Transport Assessment Review - Proposed Mixed Use Development – Chidswell, Dewsbury

PREPARED FOR: Paula Bedford (Highways England)
PREPARED BY: Jack Fawdington (CH2M)
DATE: 3rd September 2020
PROJECT NUMBER: DevWY0010
DOCUMENT REF: TM004
REVIEWED / APPROVED BY: Richard Edwards (CH2M)

CH2M (on behalf of Highways England) has undertaken a review of a Transport Assessment [TA] and Framework Travel Plan [FTP] that have been submitted to Kirklees Council [KC] for the planning applications referenced 2020/92331 and 2020/92350, both located on adjacent plots on land to the east of Leeds Road, Chidswell, Dewsbury. The 2020/92331 application seeks outline planning permission for the demolition of existing dwellings and development of phased, mixed-use residential scheme, comprising up to 1,354 dwellings, up to 35 hectares of B1 / B2 / B8 uses, a local centre, primary school, access and associated infrastructure. This aspect of the development is understood as site B. The 2020/92331 application seeks outline planning permission for the development of up to 181 residential dwellings, engineering and site works, the demolition of existing properties and associated infrastructure. This aspect

Figure 3.1: Routing IDs to/from MXS7 used in Pell Frischmann TA submission Appendix E

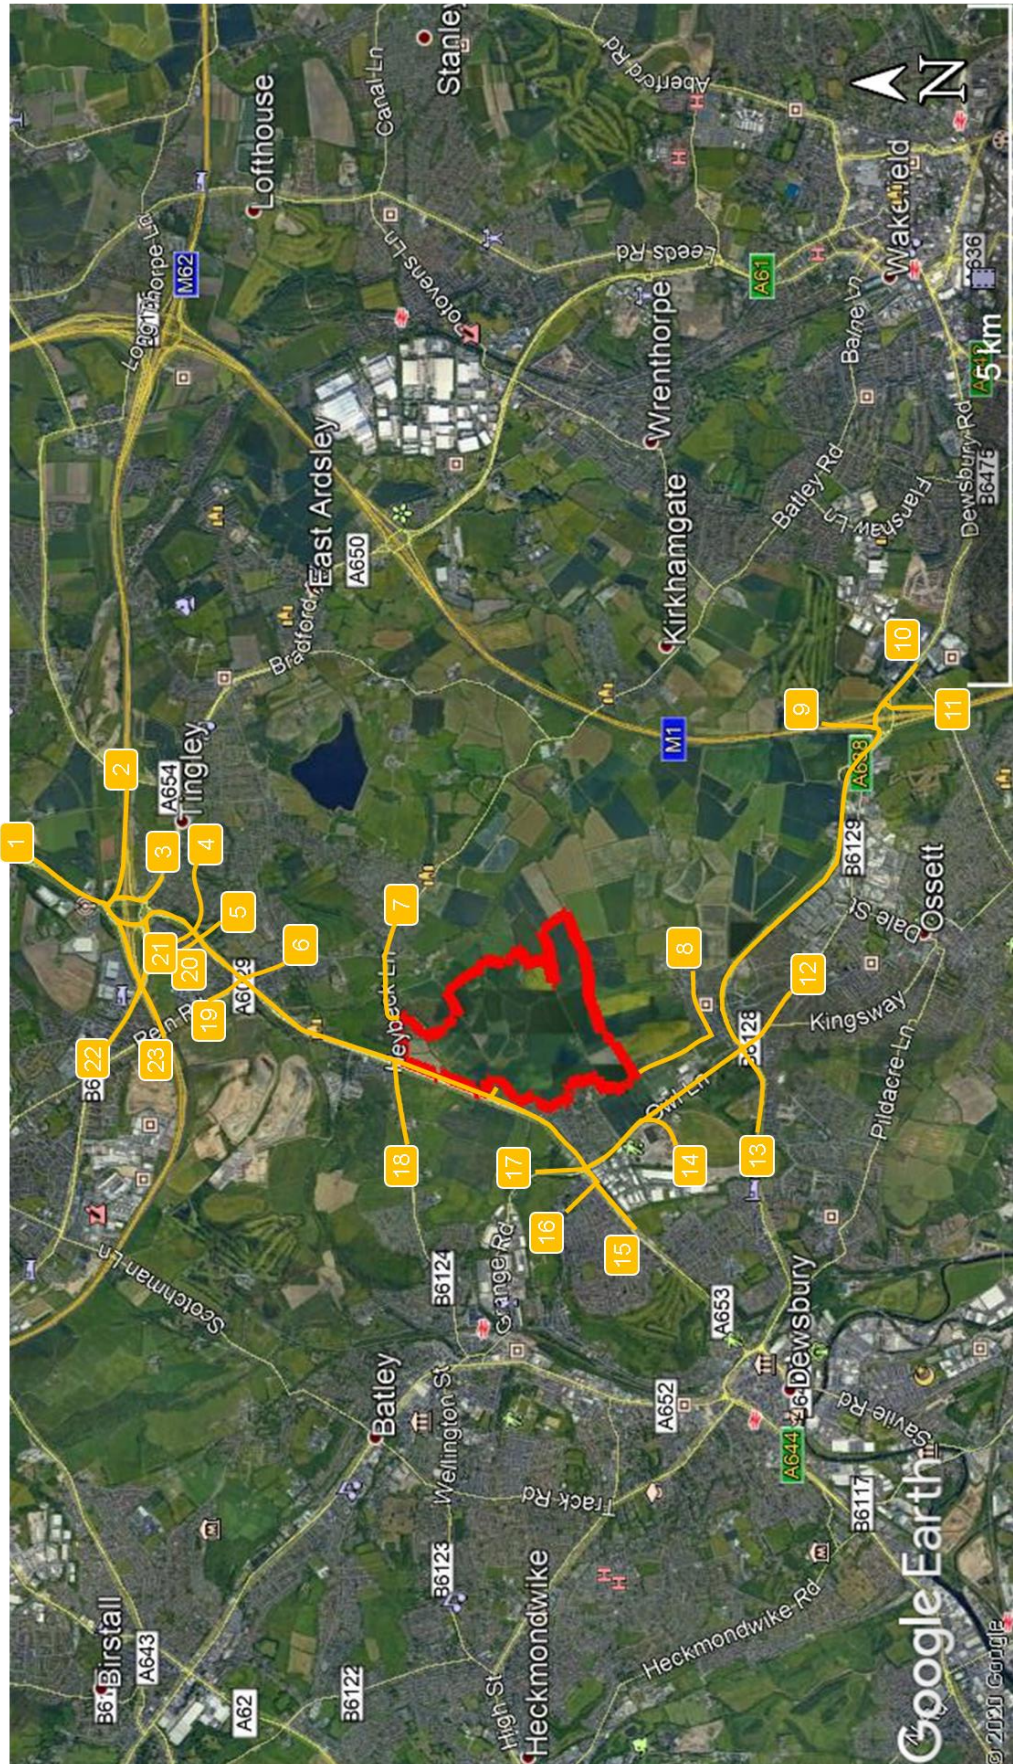
- It is acknowledged that Appendix E contains the spreadsheet route assignment methodology utilised by Pell, however, for both residential and employment trips, the calculations provided fail to name each specific route identified. Proposed routes are instead identified as 1 through to 23.
- Until the specific routes to be utilised by development traffic is clarified by Pell, the proposed trip distribution methodology cannot be fully evaluated or accepted by CH2M.

- 5) It is acknowledged that Appendix E contains the spreadsheet route assignment methodology utilised by Pell, however, for both residential and employment trips, the calculations provided fail to name each specific route identified. Proposed routes are instead identified as 1 through to 23.
